KITTITAS COUNTY COMMUNITY DEVELOPMENT SERVICES

RE: Brethren Frontier School Conditional Use Application (CU-22-00003) – Transmittal of Comments and Request for additional information.

1061 EMERSON RD
PROPOSED MULTI PURPOSE BLDG
1" = 10'

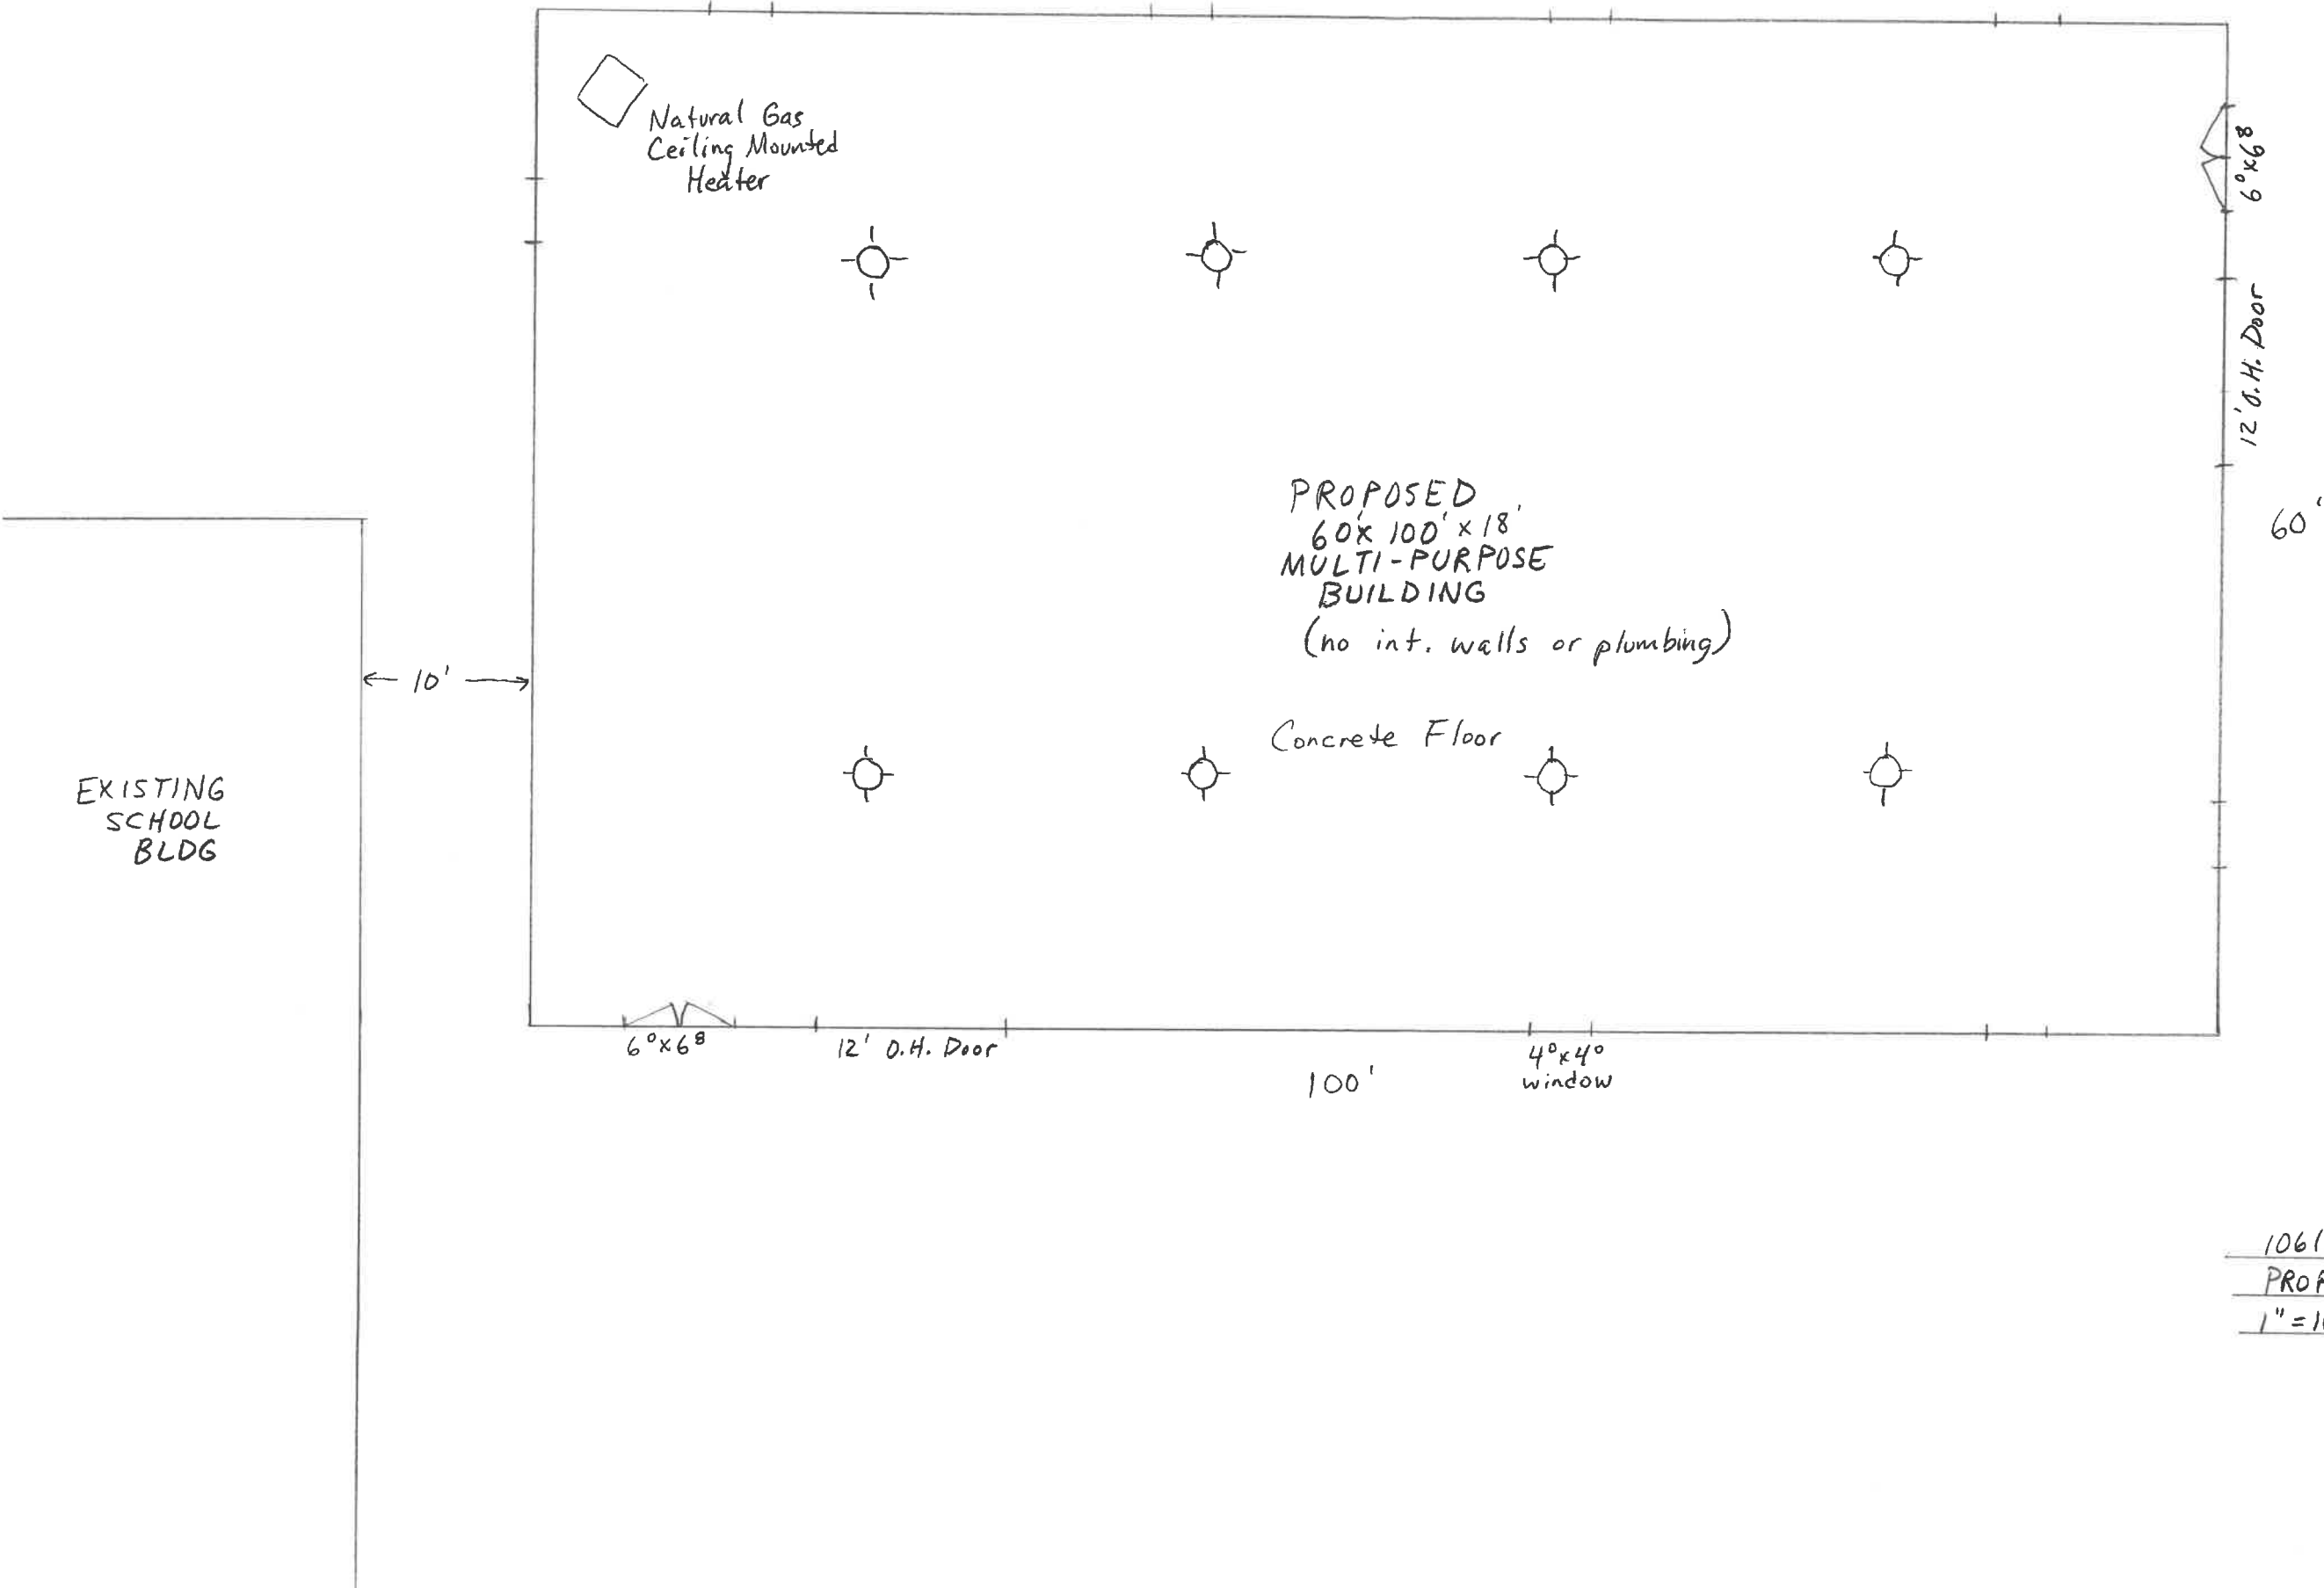
Kittitas County Public Health comments specifically address an issue with the location of the existing driveway and parking. It appears the driveway and parking currently goes over and sits on top of the drainfield. CDS is requesting the applicants address this concern and submit an amended site plan amending the driveway and parking areas to be outside the drainfield. Please include the drainfield location on the new site map.
